## *Rezoning Petition Review*

**Rezoning Petition #:** 20-11

**Location of Property:** Approximately 1.35 acres located west of Margaret Wallace Rd and northeast of Glen Lyon Dr.

MARGARET WALLACE SUBDIVISION
 CHARLOTTE, NORTH CAROLINA
REZONING SITE PLAN

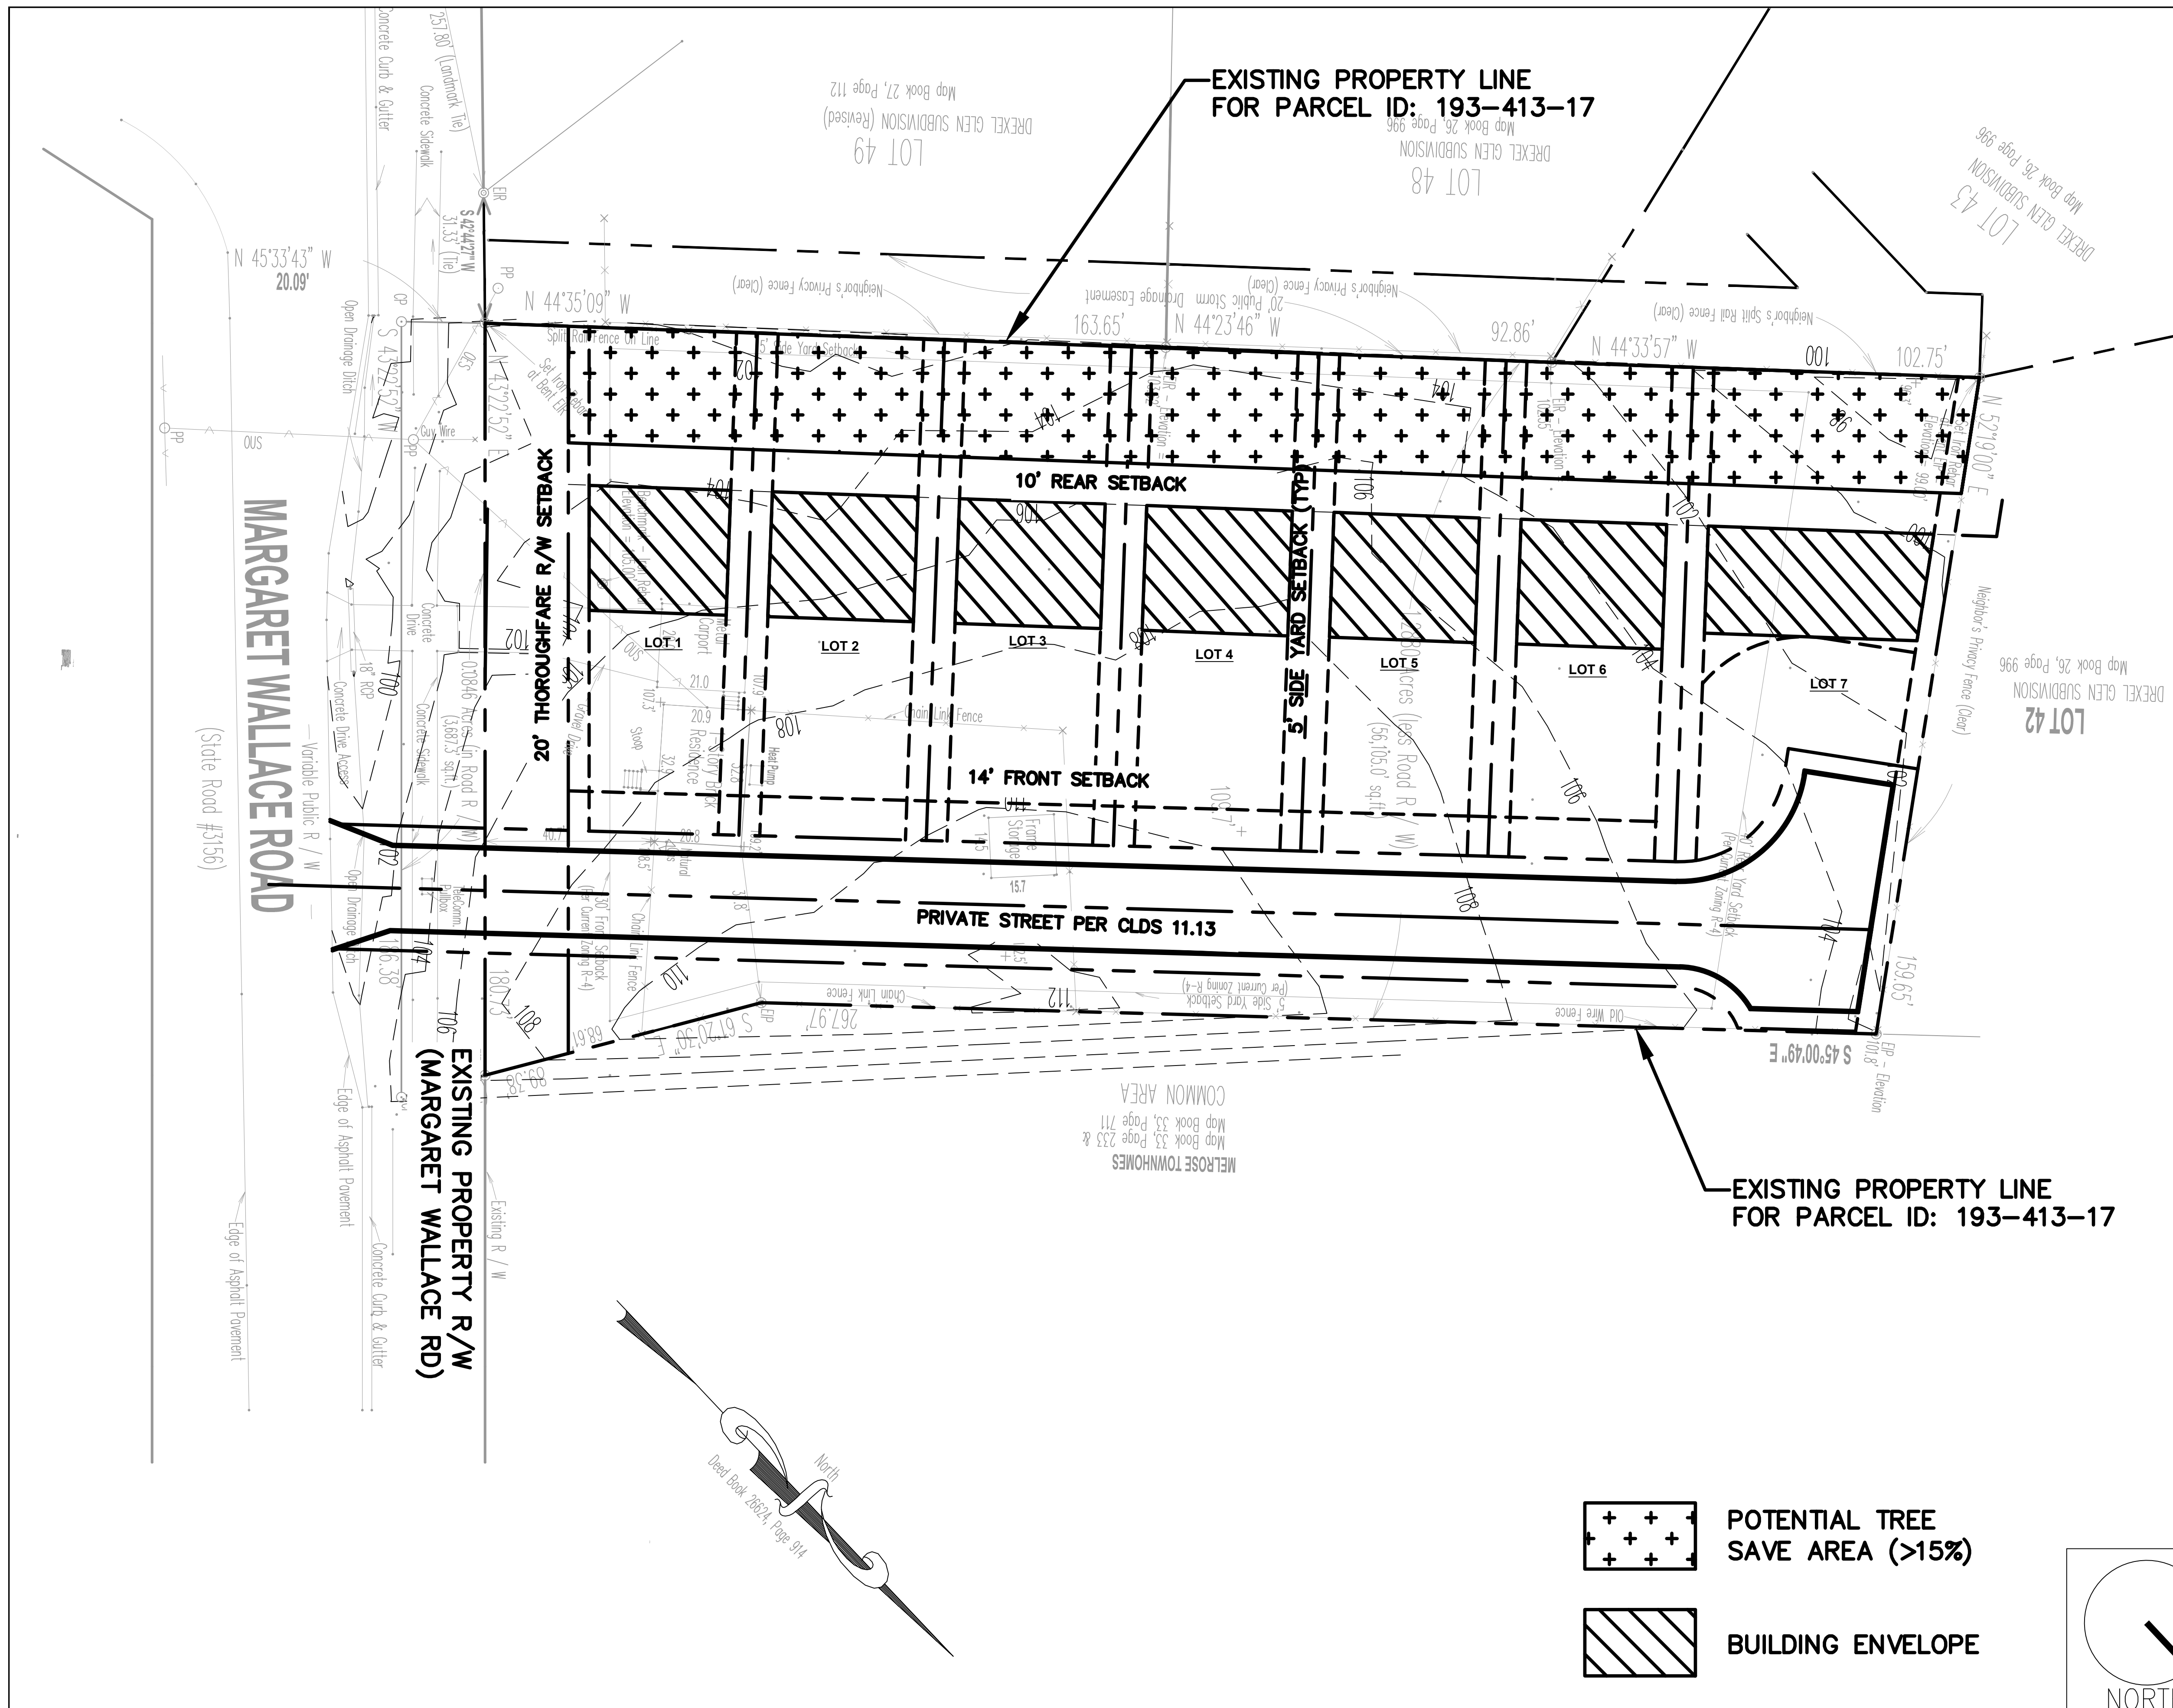
**Recommendations Concerning Storm Water:** Please add the following notes to the site plan under *Environmental Features*: *"The petitioner shall tie-into and analyze the adequacy of the existing storm water conveyance to the nearest public right-of-way. If the existing storm water conveyance is found to be inadequate, the Petitioner shall make a good faith effort to improve the storm water conveyance or mitigate the storm water discharge."*
